Approval of details reserved by condition imposed under ref AL/51/20/PL relating to Condition Nos 10 - surface water drainage and 11 - discharge flows to watercourses

Tyrone House Norton Lane Norton PO20 3NH

Arun District Council have decided to **REFUSE details reserved by condition for the following reasons:**

| DRAWING TITLE<br>DRAINAGE LAYOUT          |            |          |            |             |     |

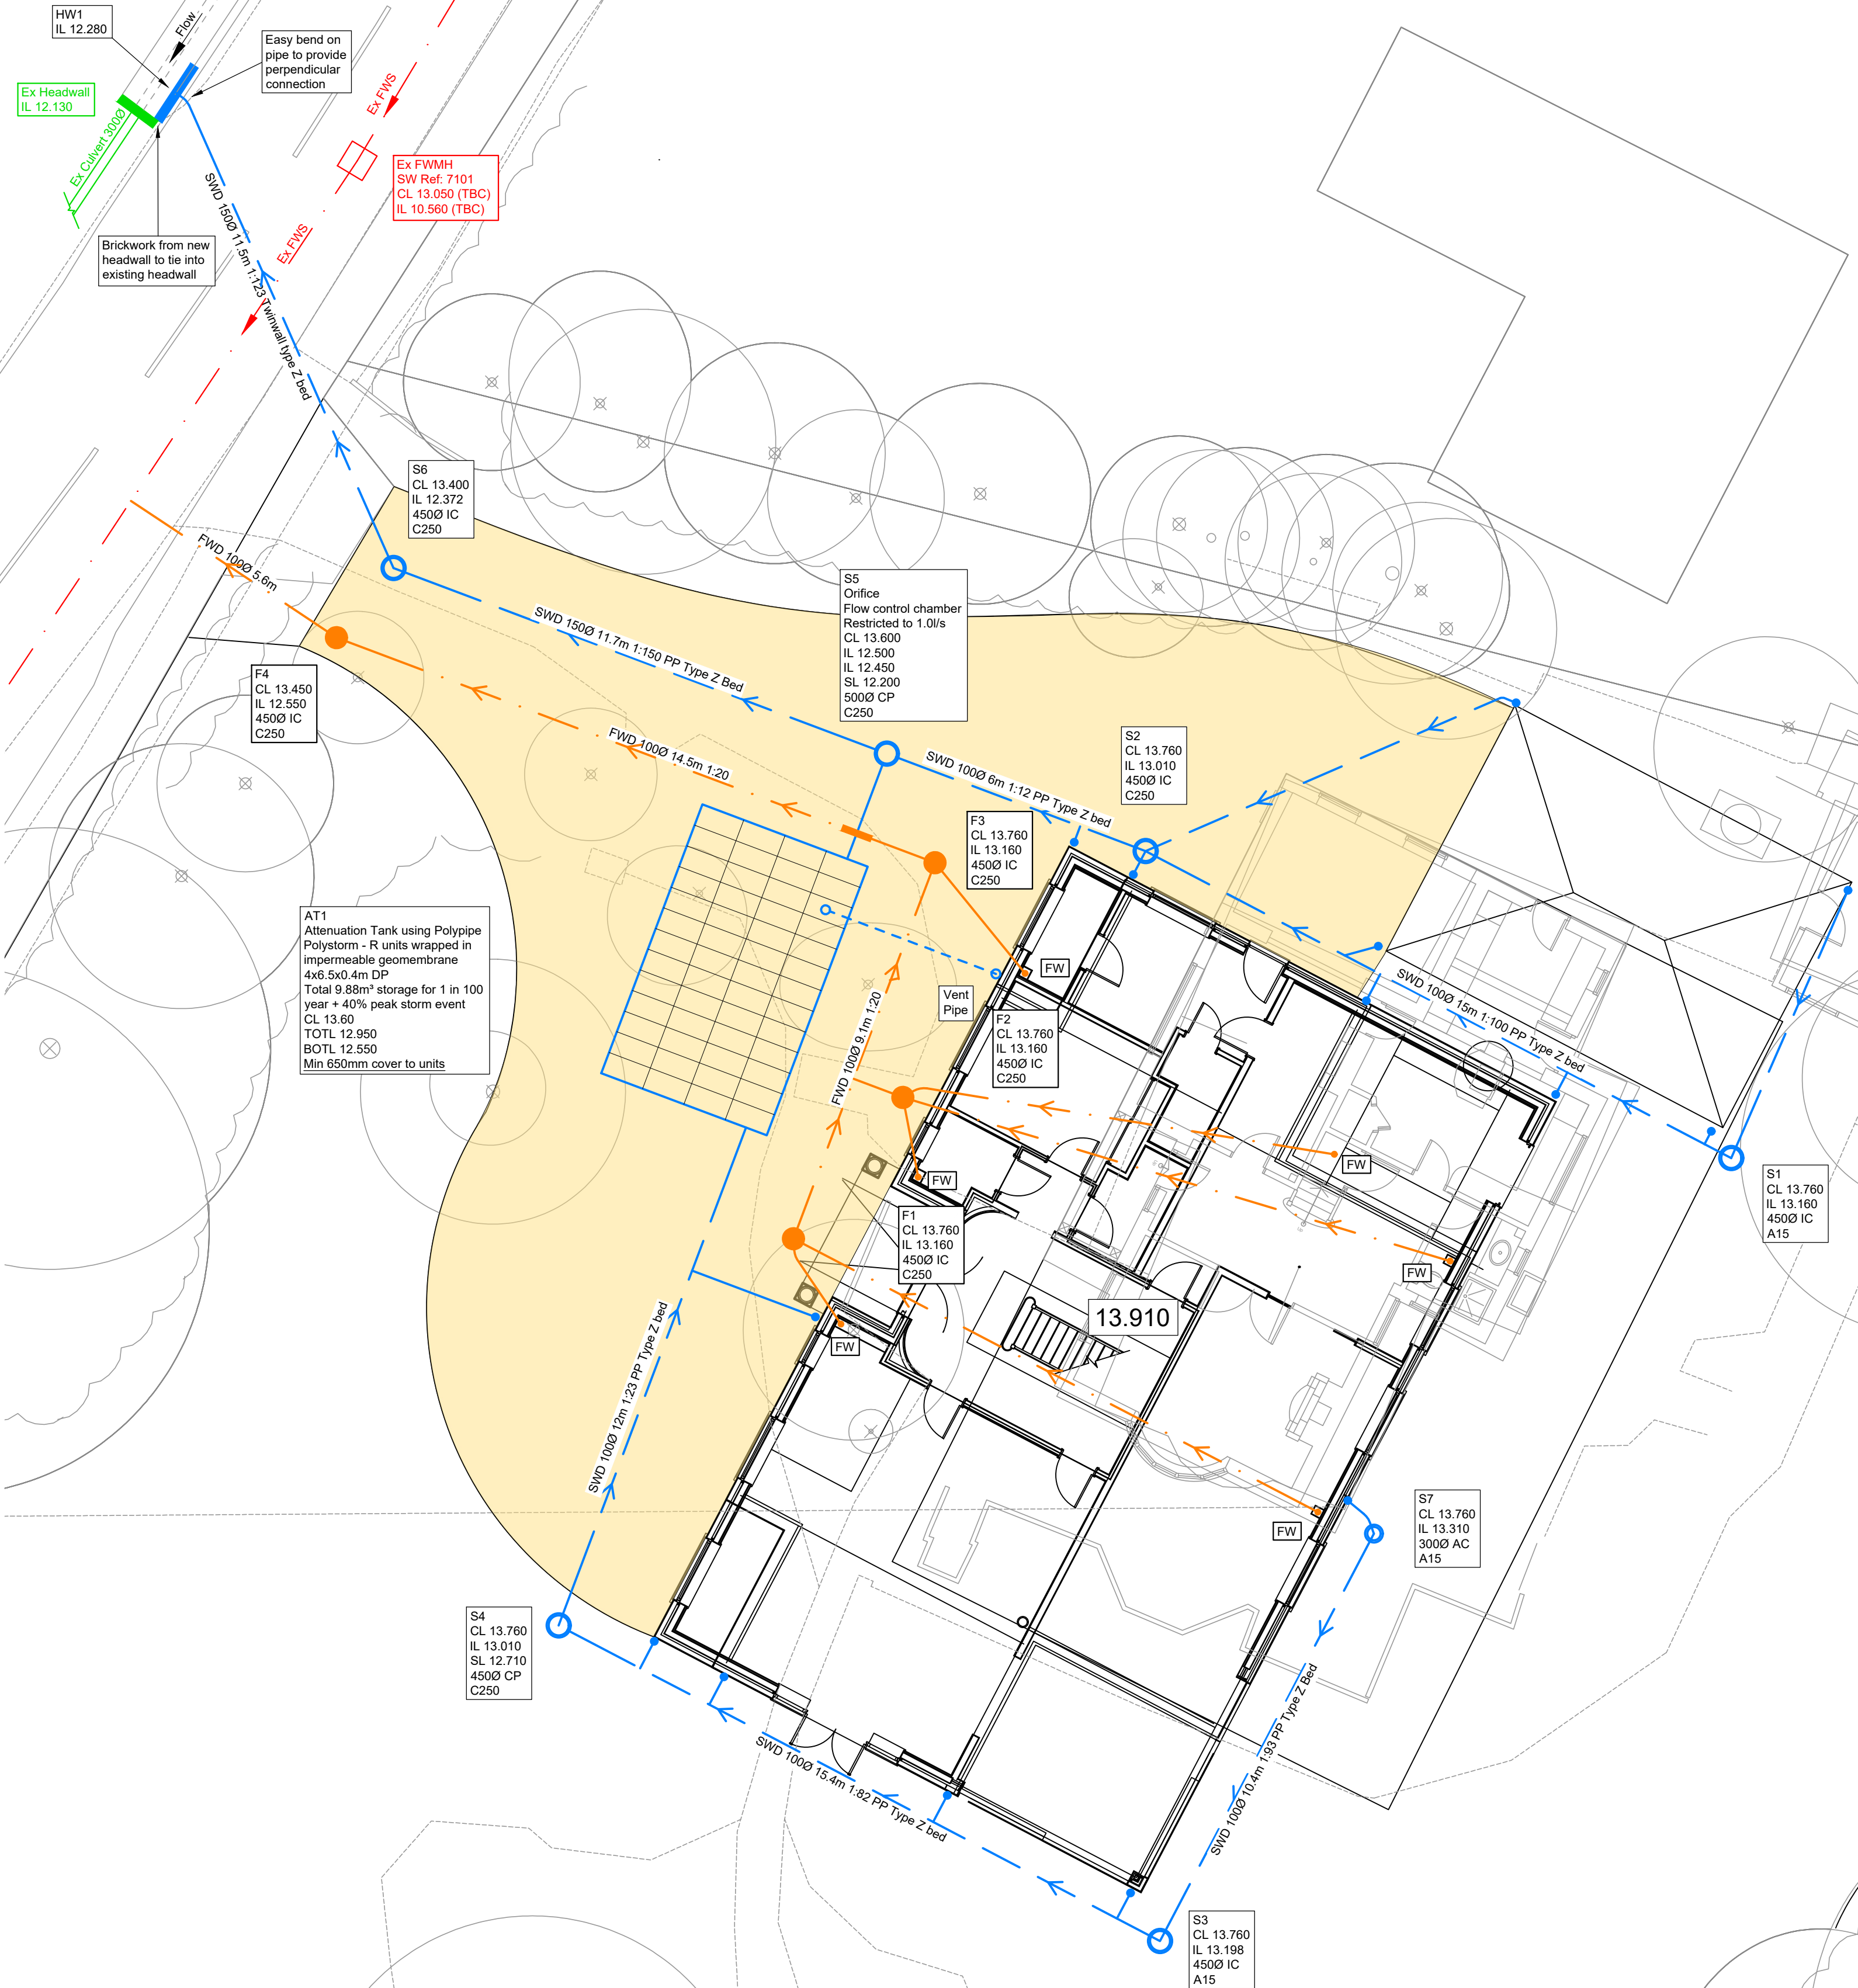
Drainage Officers recommend the discharge condition 11 is refused.

Until it is demonstrated that the site can be drained to an acceptable discharge location it is not possible to approve drainage proposals under this application. Any alterations to discharge location, or point of connection, will impact upon the wider proposed drainage scheme. It is essential to know the discharge location to be able to assess whether proposals are adequate and will not increase flood risk elsewhere. Relevant policy WDM3

As such, the condition cannot be discharged and you will need to make a revised submission.
